## Review Comments

Draft Jimmy Camp Creek Drainage Basin Planning Study September 7, 2023

Submitted by: Kiowa Engineering November 10, 2023

Figure 3-8: Jimmy Camp Creek - Existing Deficiencies

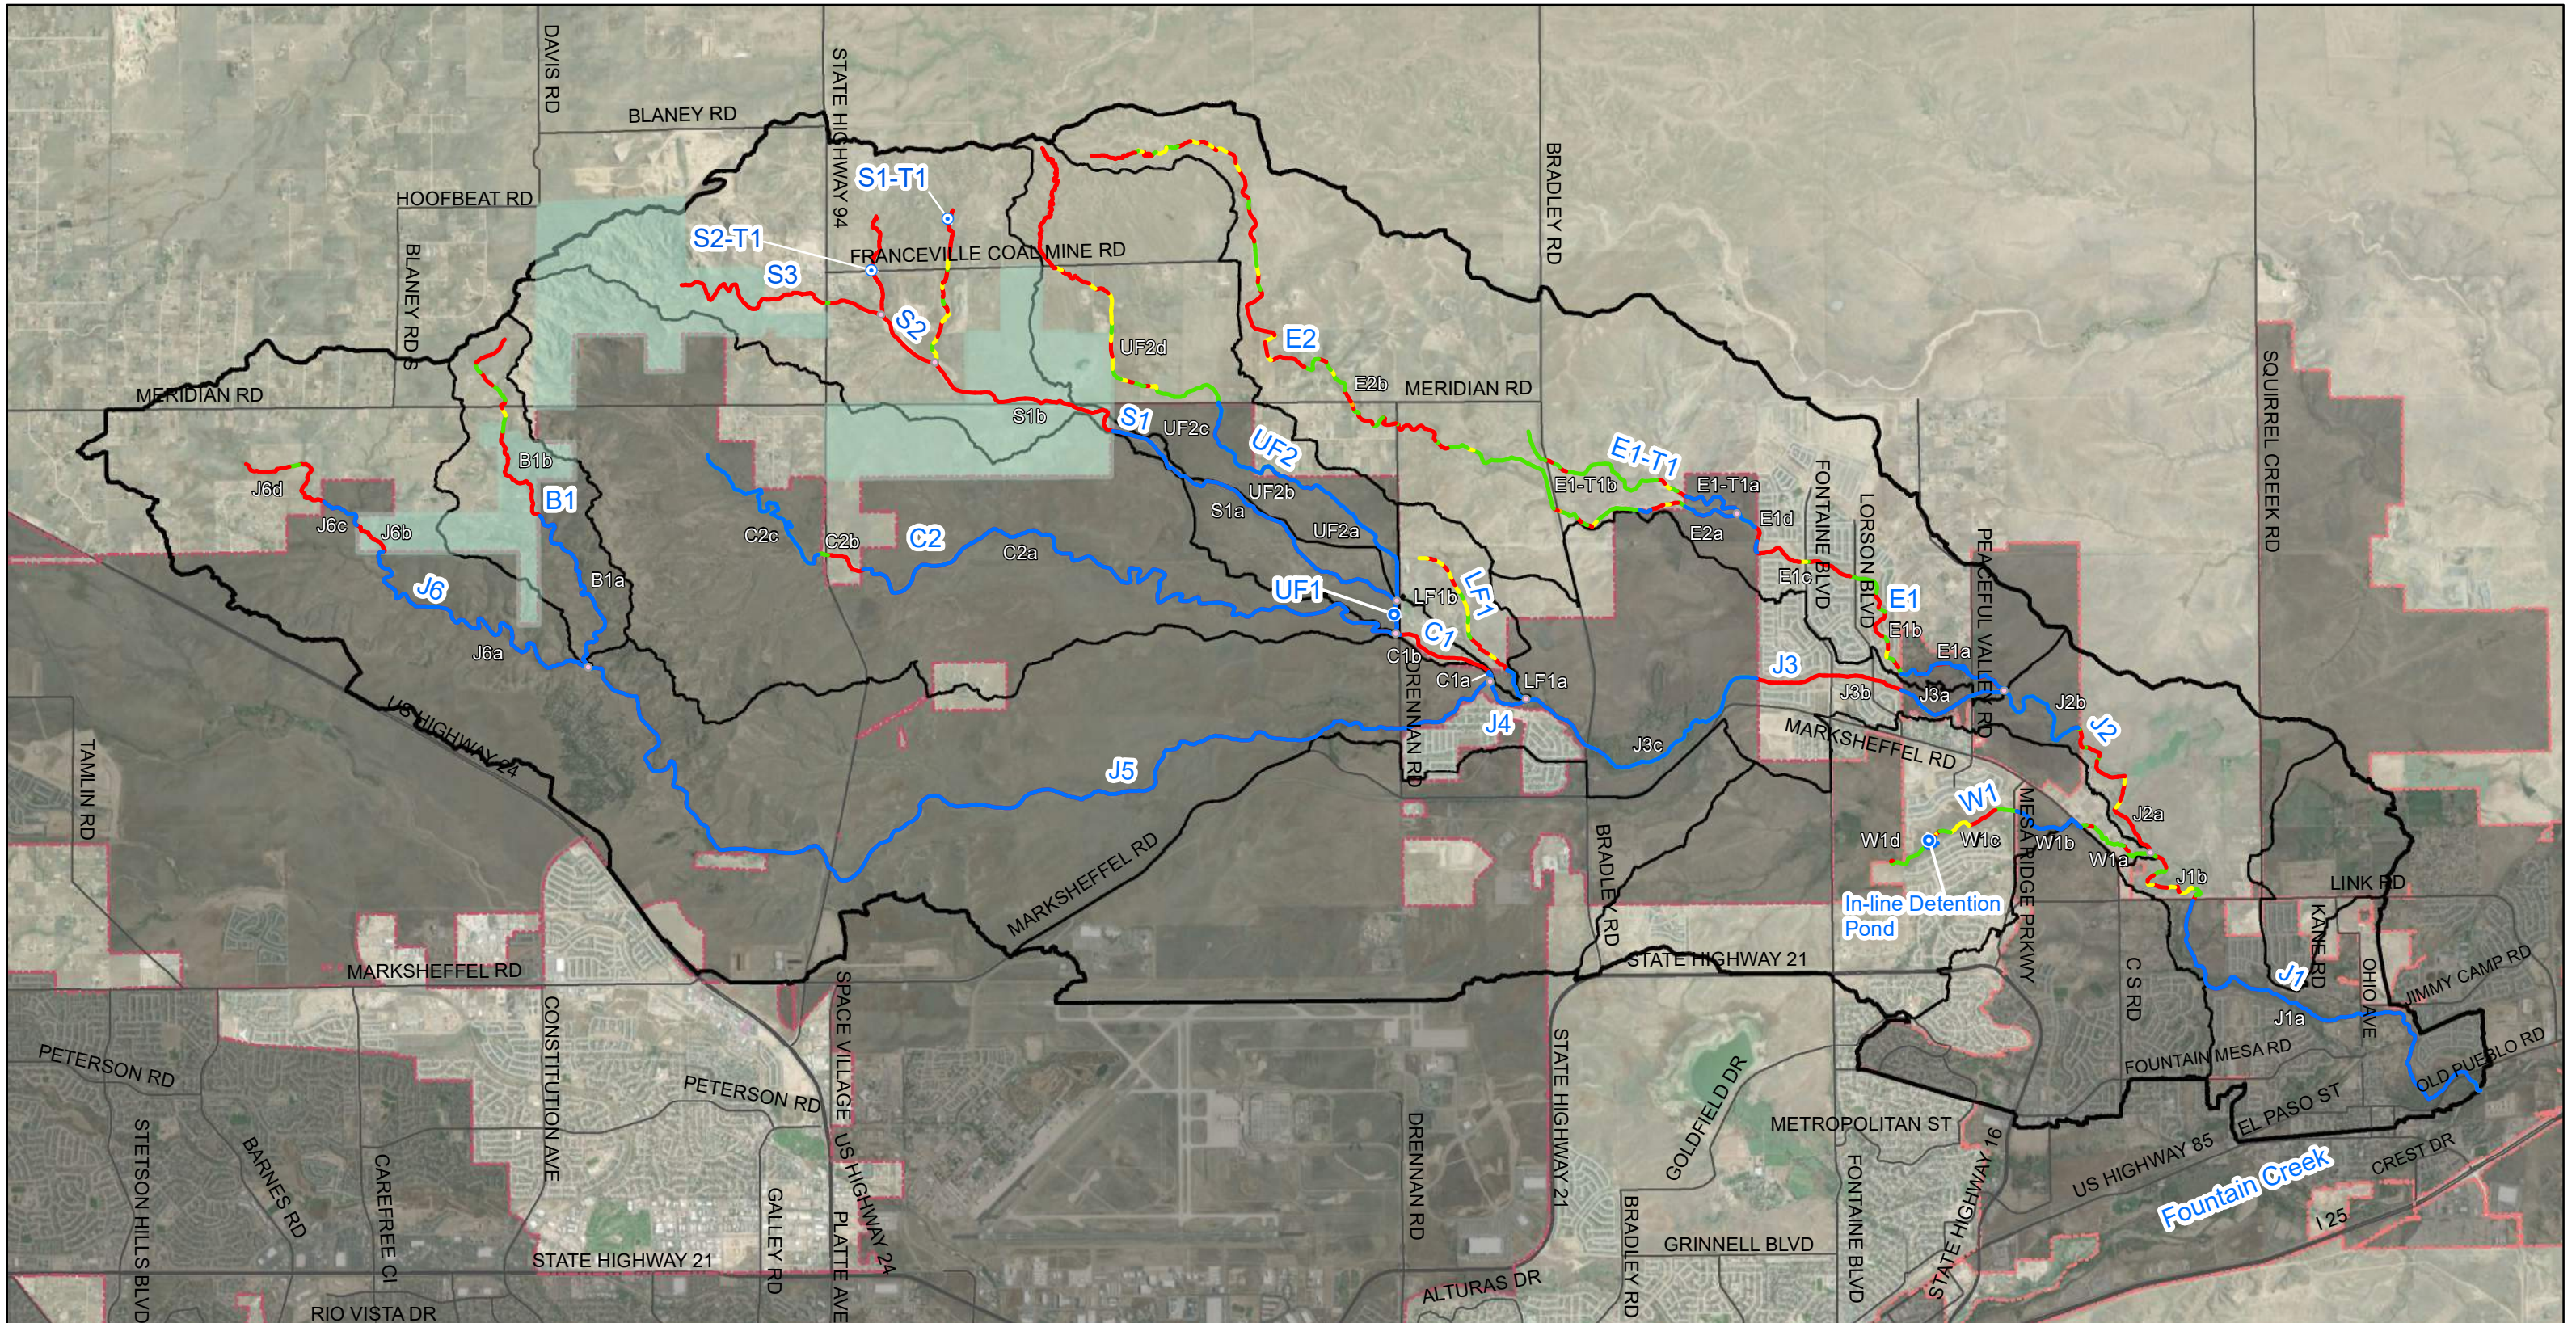
4. All of the major drainageways through Lorson Ranch have been constructed. These reaches are shown as existing deficiencies on Figure 3-8. While it is understood that the term “deficiency” is being used based upon the velocity and shear stress criteria set forth in the draft report section 2.0, this is confusing and does not accurately convey the actual stability of the constructed improvements in reach E1.

Figure 2-5: NWI Emergent Wetland Areas in Upper Jimmy Camp Creek Drainage Basin

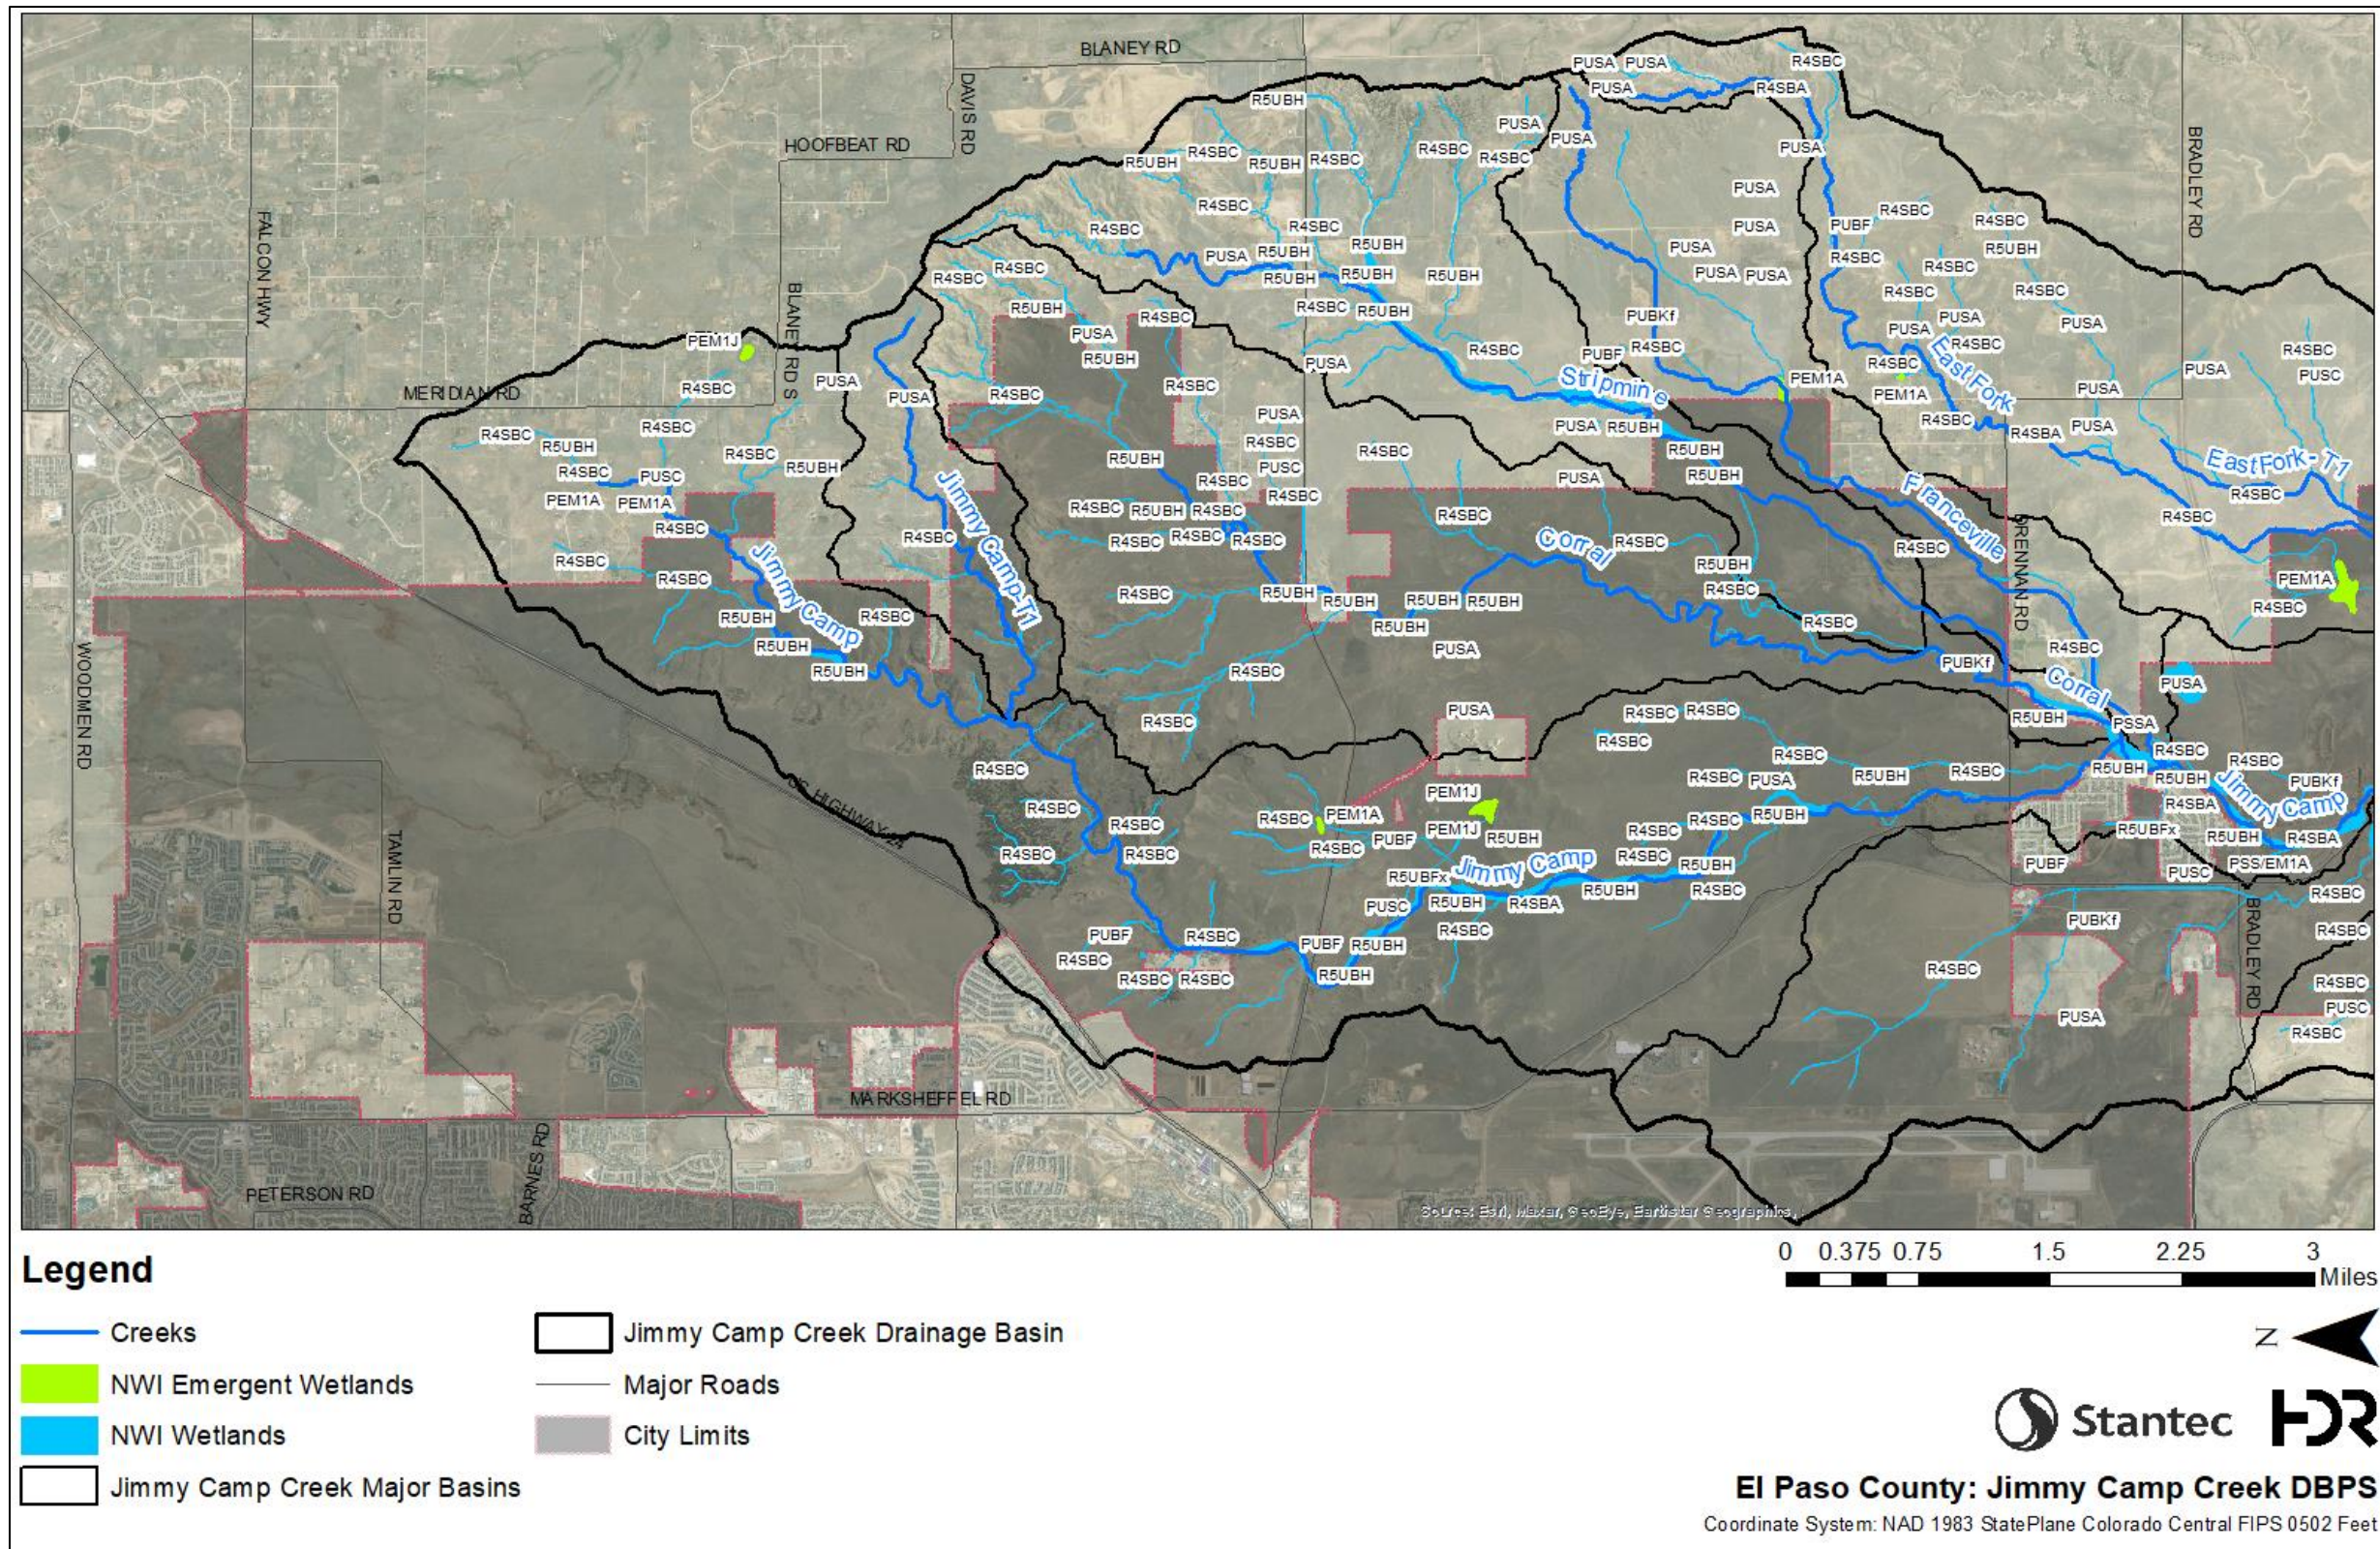
- 1, General comment: The figures in the report, especially those figures pertaining to reach delineation, are hard to read due to the font sizes and font type. Might want consider revising these figures to make for easier viewing (e.g. Figures 2-5, 2-6, and 4-3). Road names would be helpful on Figure 4-6.
